## **BCA Assessment Report**

**M7 CCA Preform Injection Moulding Plant  
9 Roussell Road, Eastern Creek**

**Goodman Property Services**

12 November 2010

PROPOSED PET FACILITY
LEVEL 1 FLOOR PLAN

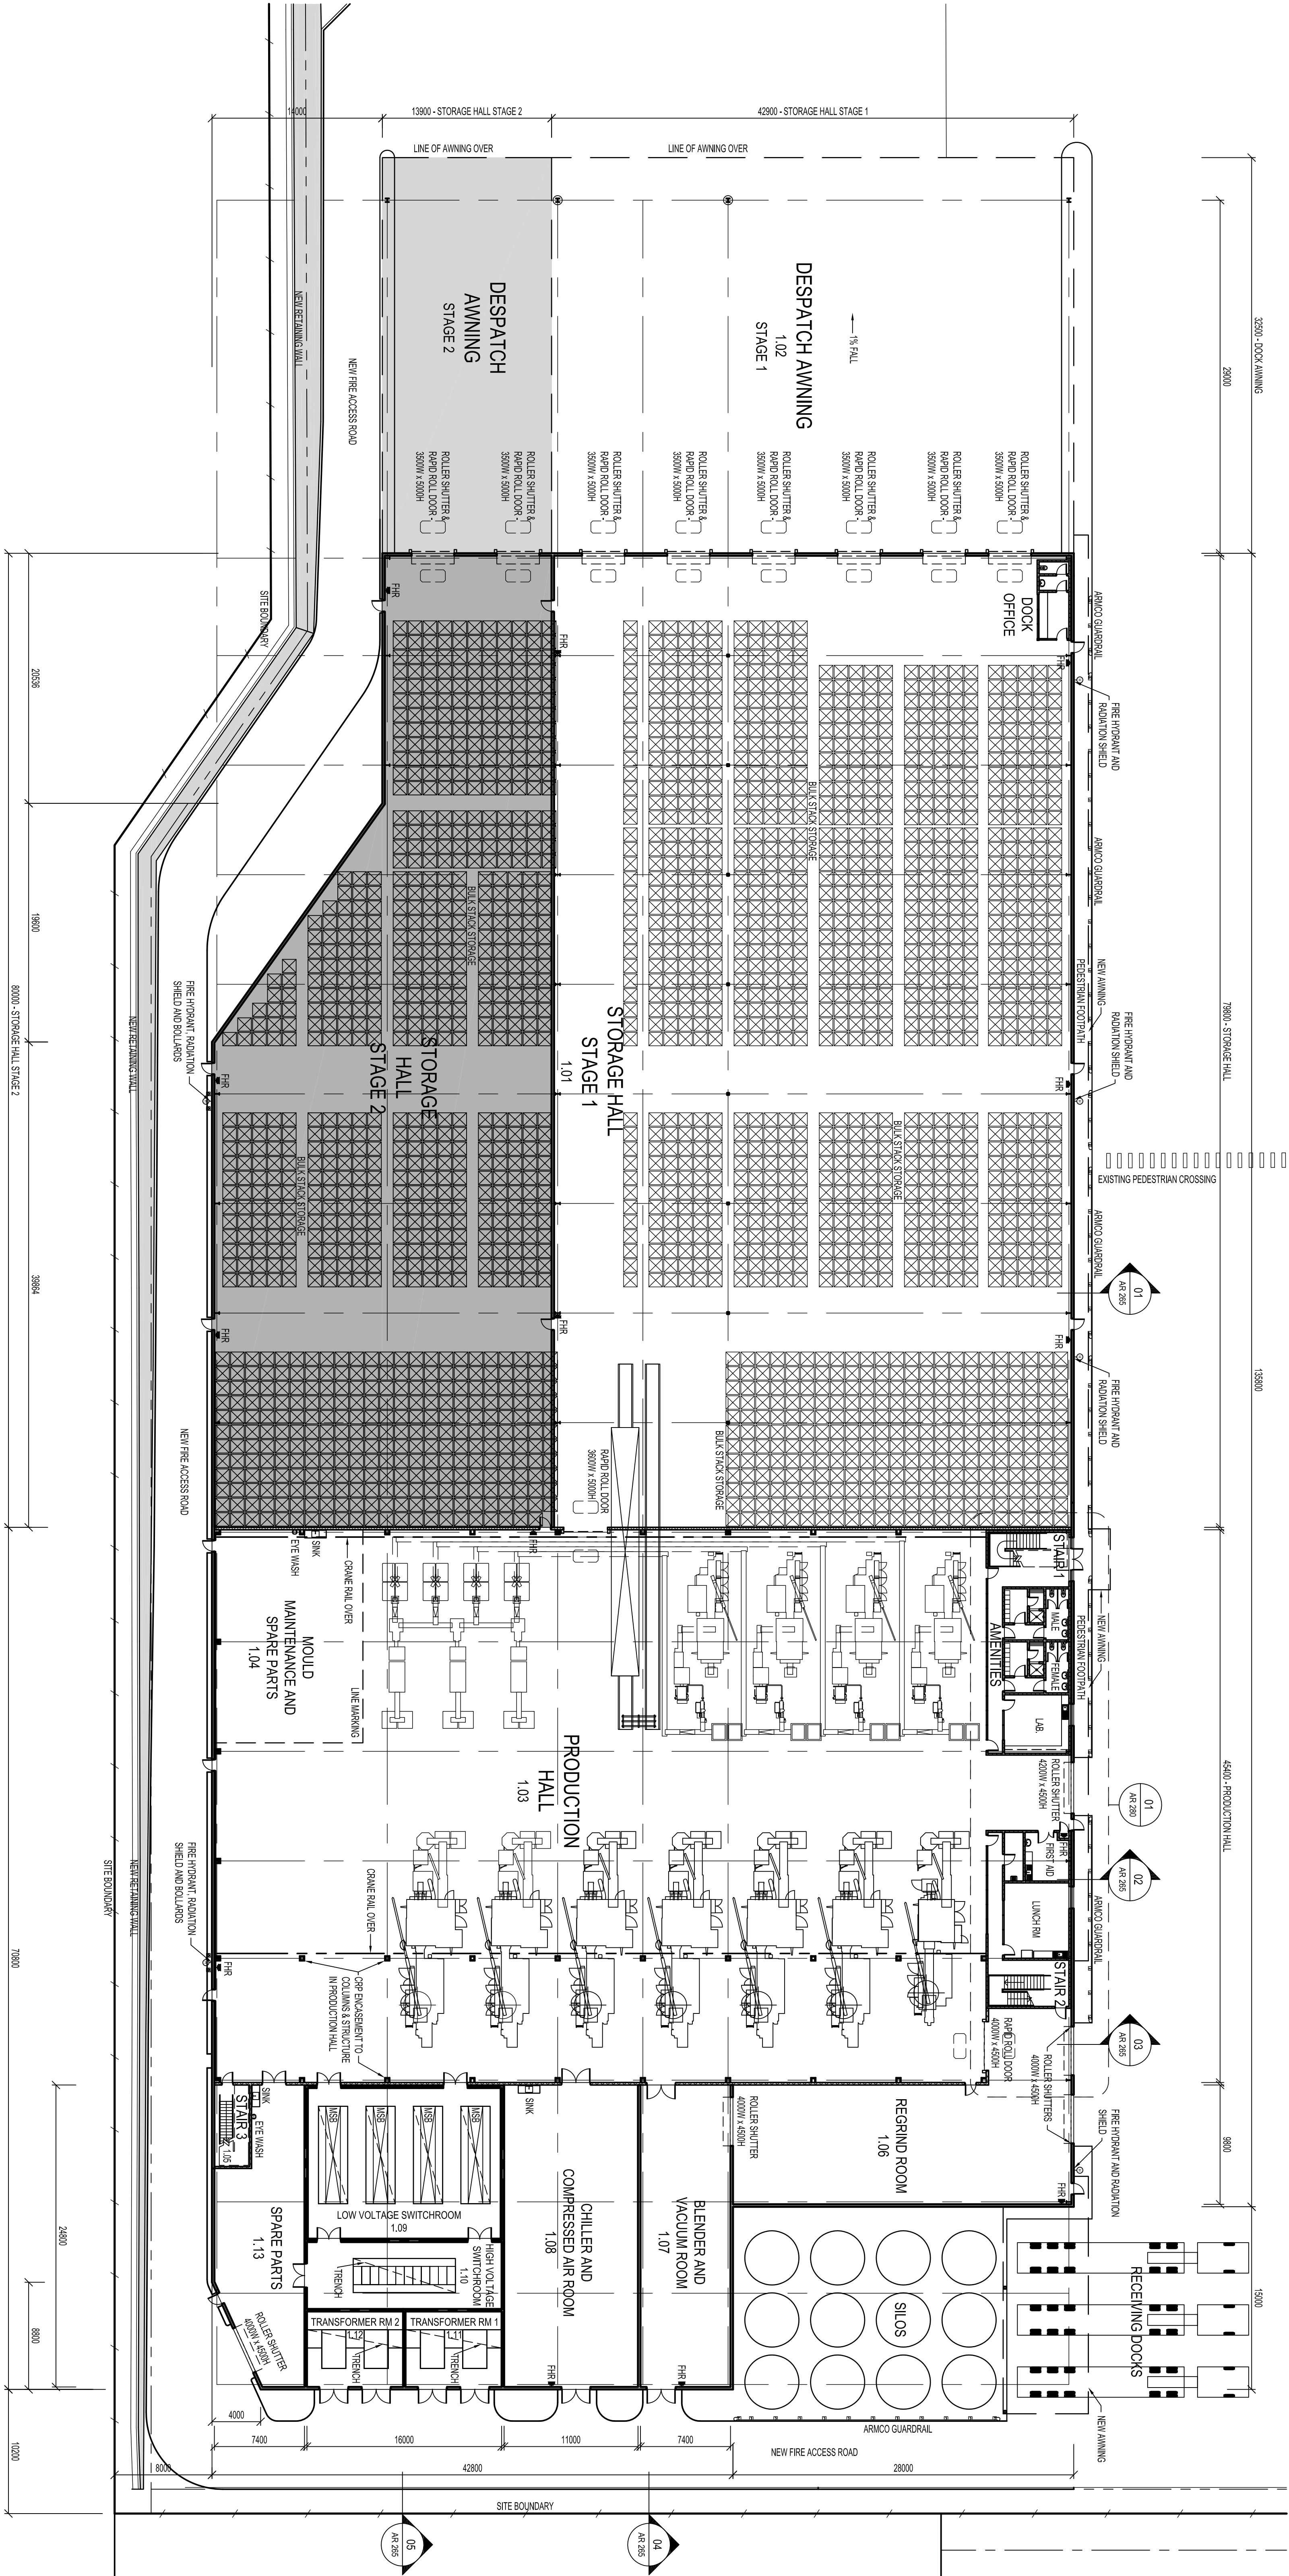
9. BCA cl. D1.4 Exit Travel Distance: The proposed building does not comply with the 40m exit travel distance requirement under this clause. In this regard the following non-compliances are noted:

- Maximum exit travel distance measured from the central area of the Stage 2 Warehouse is approx. 45m. Note: The completed Stage 1 Warehouse is compliant with D1.4.

- Maximum exit travel distance measured from the Stage 1 Production Hall is approx. 52m.
- There is a potential dead end travel distance issue within the stage 2 warehouse. This would only be applicable if there was a wall separating stage 1 and 2 warehouse areas, however it has been confirmed by the architects that there will not be wall separating the two stages once stage 2 is complete, based on this the travel distances will be compliant in that area.

- The travel distance to a point of choice within the plant platform room 2.04 exceeds 20-metres. As such an additional exit door would be required in the wall of the A/C plant room 2.03, so that a point of choice is provided.

- The travel distance from the regrind room to the exit is 28-metres in lieu of 20-metres.

10. BCA cl. D1.5 Distances Between Alternative Exits: The proposed building also does not comply with the DTS maximum 60m distance required between alternative exits under this clause. The maximum distance between alternative exits was measured as follows:

- Maximum distance between alternative exits from the central area of the Stage 2 Warehouse is approx. 75m. Note: The completed Stage 1 Warehouse is compliant with D1.5.
- Maximum distance between alternative exits from the Stage 1 Production Hall is approx. 85m.
- Maximum distance between alternative exits from the Stage 1 Level 2 Mezzanine Plantroom is approx. 75m.

Note 1: It is understood that a Fire Safety Engineer is to be engaged to prepare an Alternative Solution having regard to the above non-compliance. In this regard the relevant Performance Requirements are DP4 and EP2.2.

Similarly to D1.4, it is understood that a Fire Safety Engineer has been engaged to prepare an alternative solution to address this issue, with the relevant Performance Requirements being DP4 and EP2.2 also.
